# **Harbourside Shopping Centre Redevelopment SSD-7874** Amended Concept Proposal and Stage 1 Early Works October 2020 and **Response to submissions**

My submission is to OBJECT based on the grounds that the minor changing to the northern podium do not:

NEW PUBLIC DOMAIN SPACES – GUARDIAN SQUARE AND EVENT STEPS

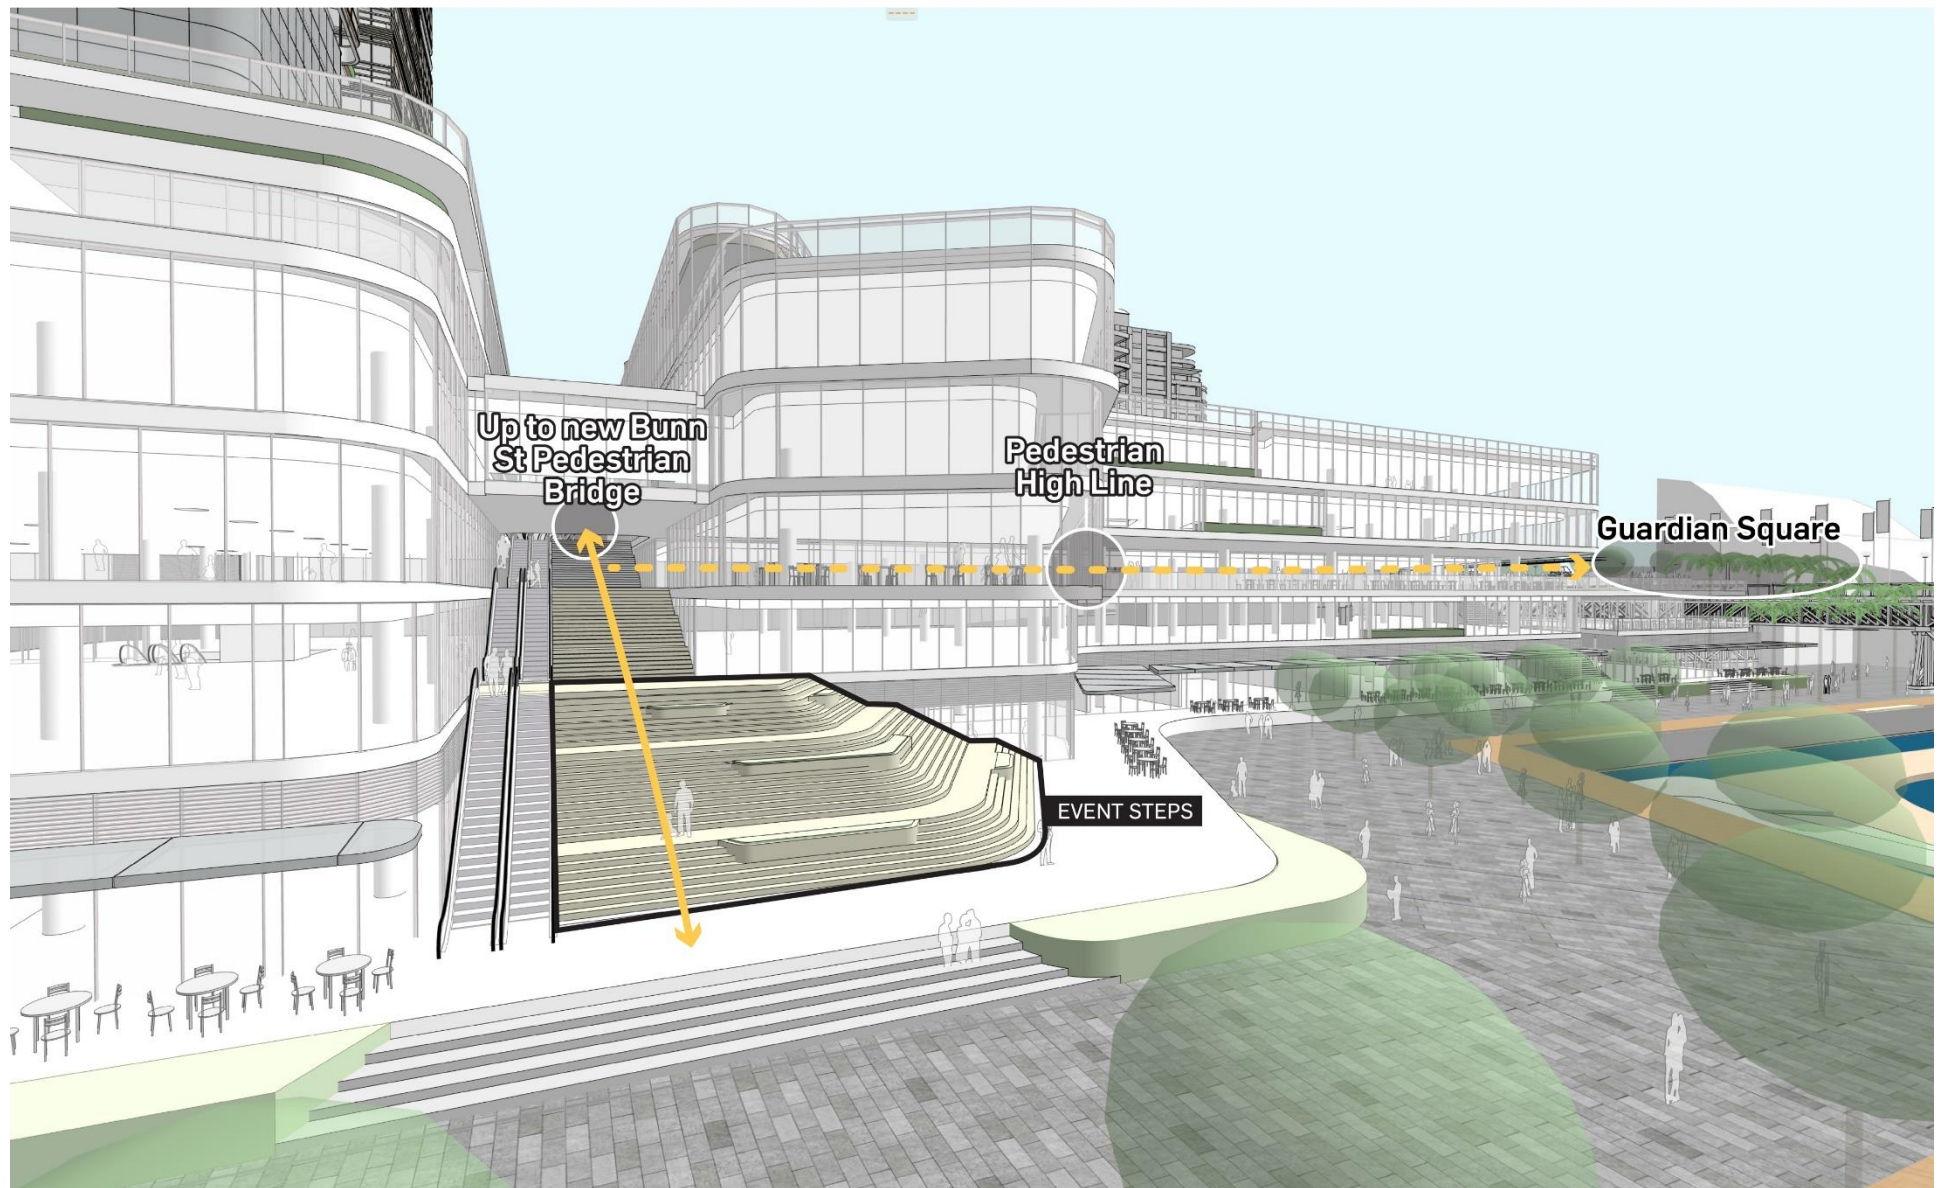
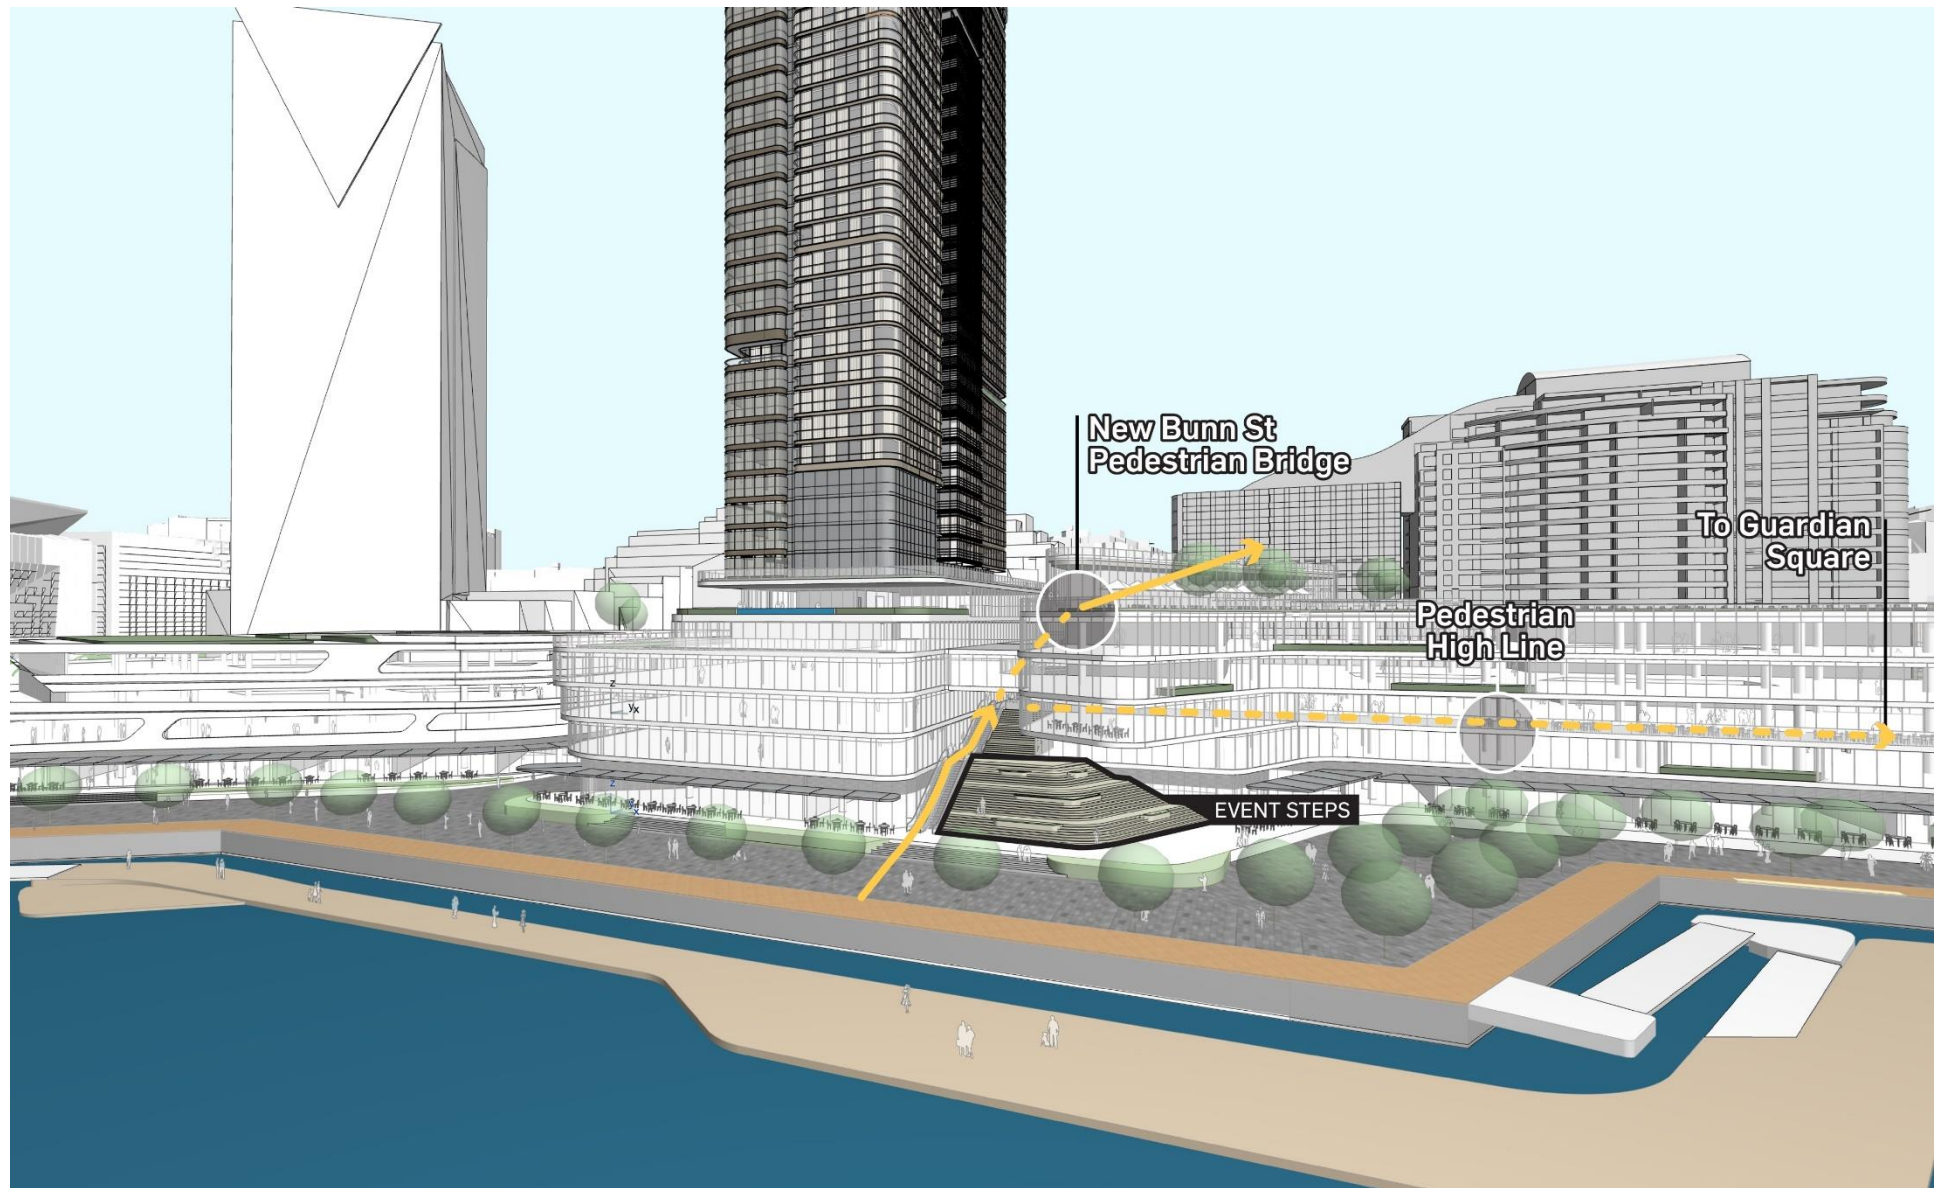
Much is made by Mirvac of providing public open space called Guardian Sqaure. However as can be seen below open space is in two levels (RL 13.75 and RL17.60) with a maximum width of some **30m**, which require families to walk up **3.85m of stairs/ramps** to enjoy it. This area will be the entrance to this community destination for families coming from the light rail at the Star stop, for Pyrmont peninsular residents, for people who park in the public carpark under 50 Murray Street and people coming over Pyrmont Bridge. It will be a very busy and active access area and limited ability to enjoy it as a park. The majority of the site function is a 'site through link' rather than a park which families can enjoy. This **clearly limits its function as quality public open space.**
